September 10, 2010

**Subject:** **Permit Modification Request for the Individual Section 404 Permit and Individual Water Quality Certification** for the proposed widening of SR 1003 (Camden Rd) from NC 59 (Hope Mills Rd) to Owen Drive (SR 1007) in Cumberland County. Federal Aid. No. STP-1003(22), State Project No. 82442601, TIP No. U-2810. Debit \$570 from WBS 34866.1.1

**Reference:** Original Permit Application requested September 24, 2008  
Section 404 Individual Permit issued February 12, 2009; USACE Permit No. SAW- 2008-02927  
Section 401 Water Quality Certification issued December 18, 2008; NCDWQ Project No. 20081731

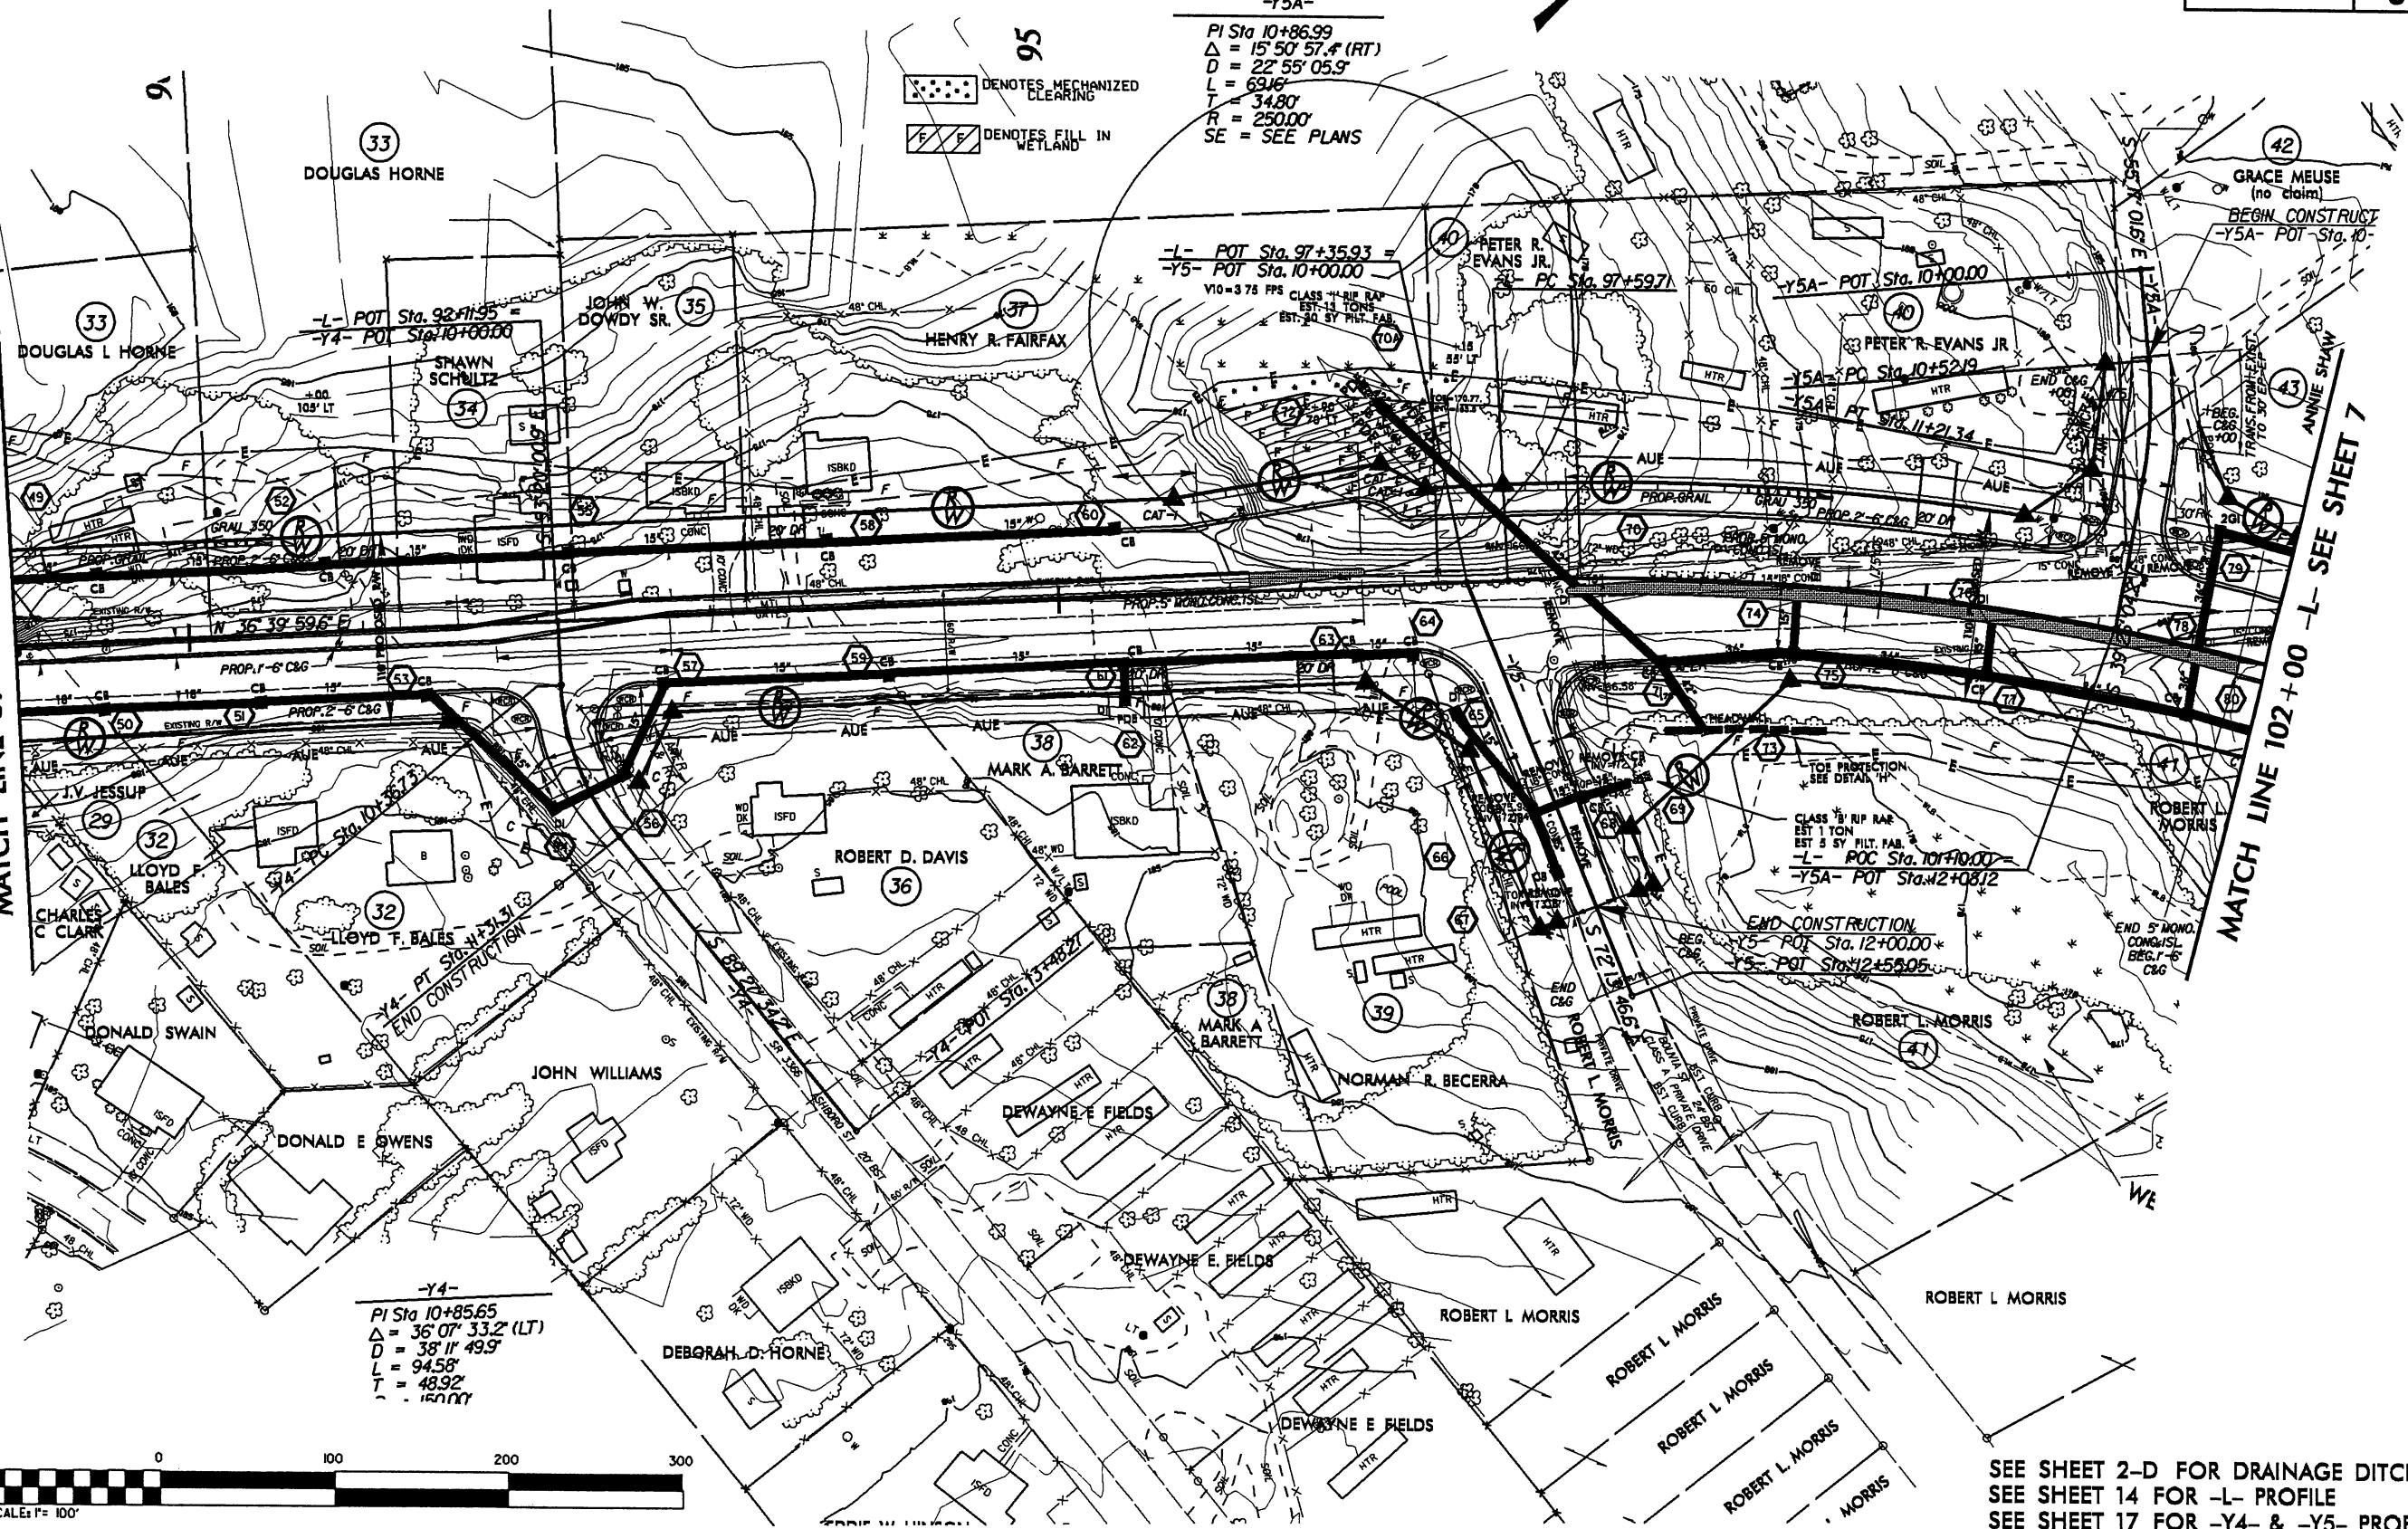
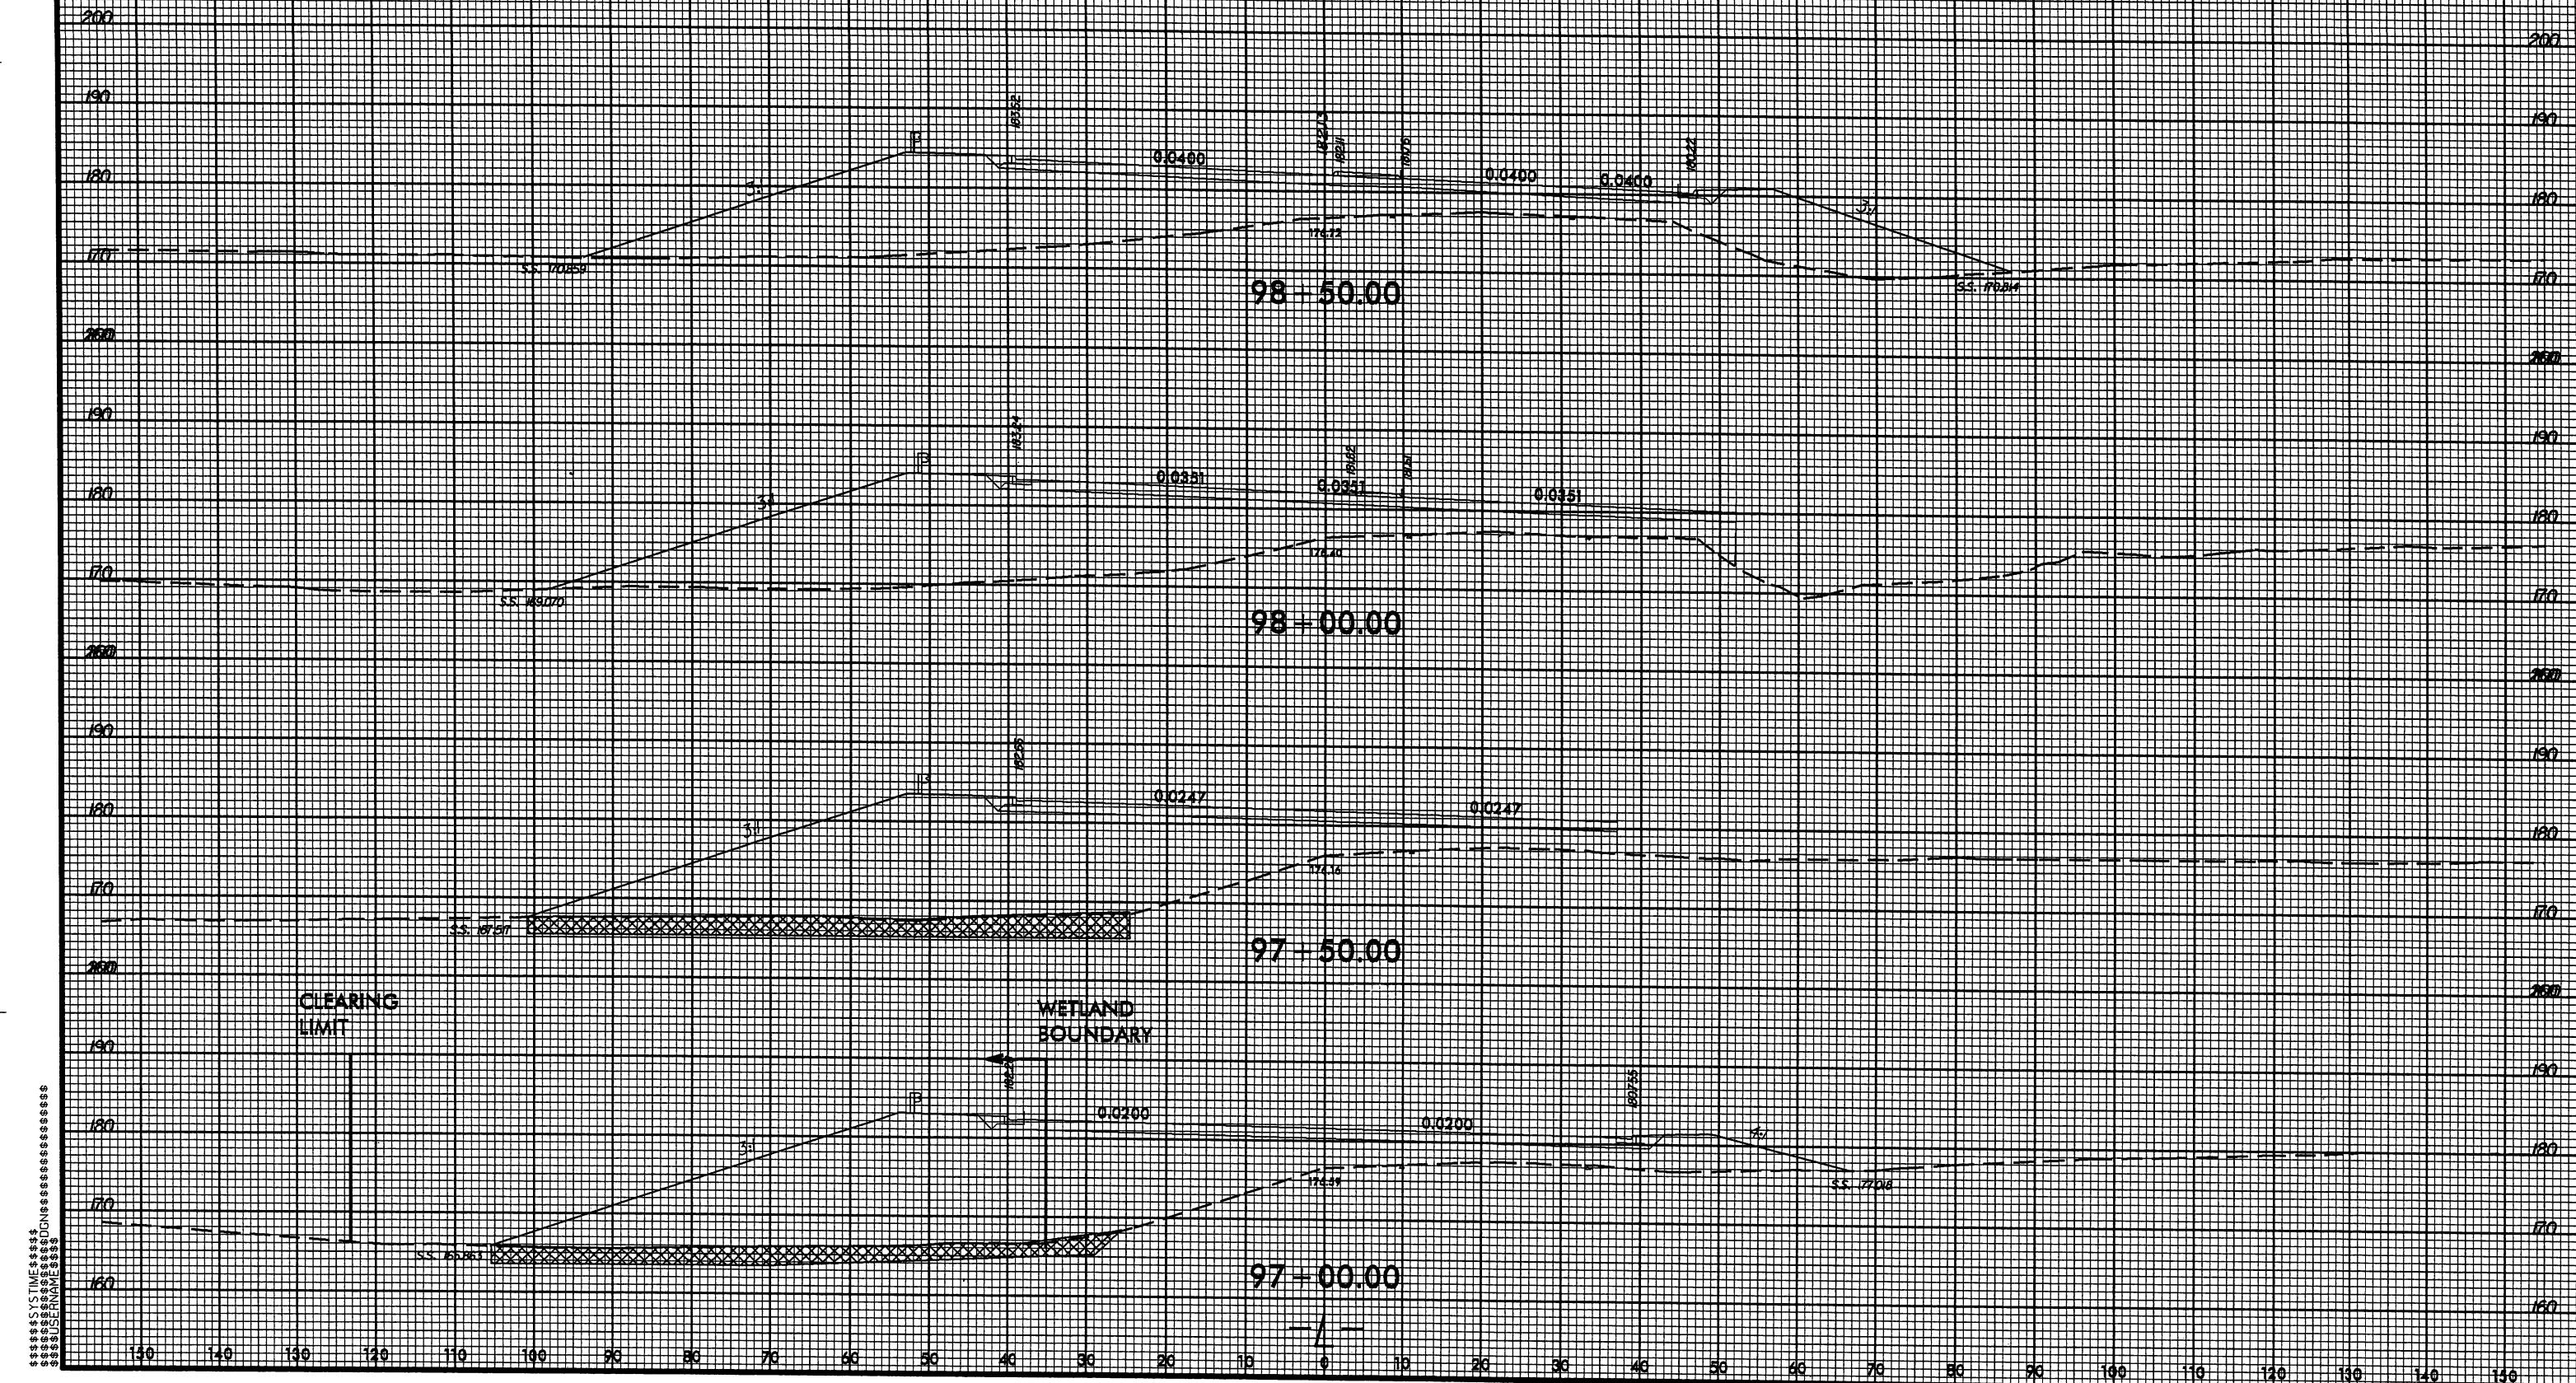
Please see the enclosed revised permit drawings, roadway plan, and revised EEP Acceptance Letter dated June 16, 2010 for the above referenced project. The presence of a wetland at site 6 (Sta. 97+36 - L-) on the U-2810 B section was determined after the Jurisdictional Determination (dated November 13, 2003) and the original permit application (dated September 24, 2008). Compensatory mitigation for the additional 0.20 acre of wetland impact will be provided by EEP. A copy of the acceptance letter is included with this request. The additional impacts of 0.20 acre increases total wetland impacts for the entire U-2810 project to 1.10 acres. Stream impacts remain unchanged at 273 linear feet.
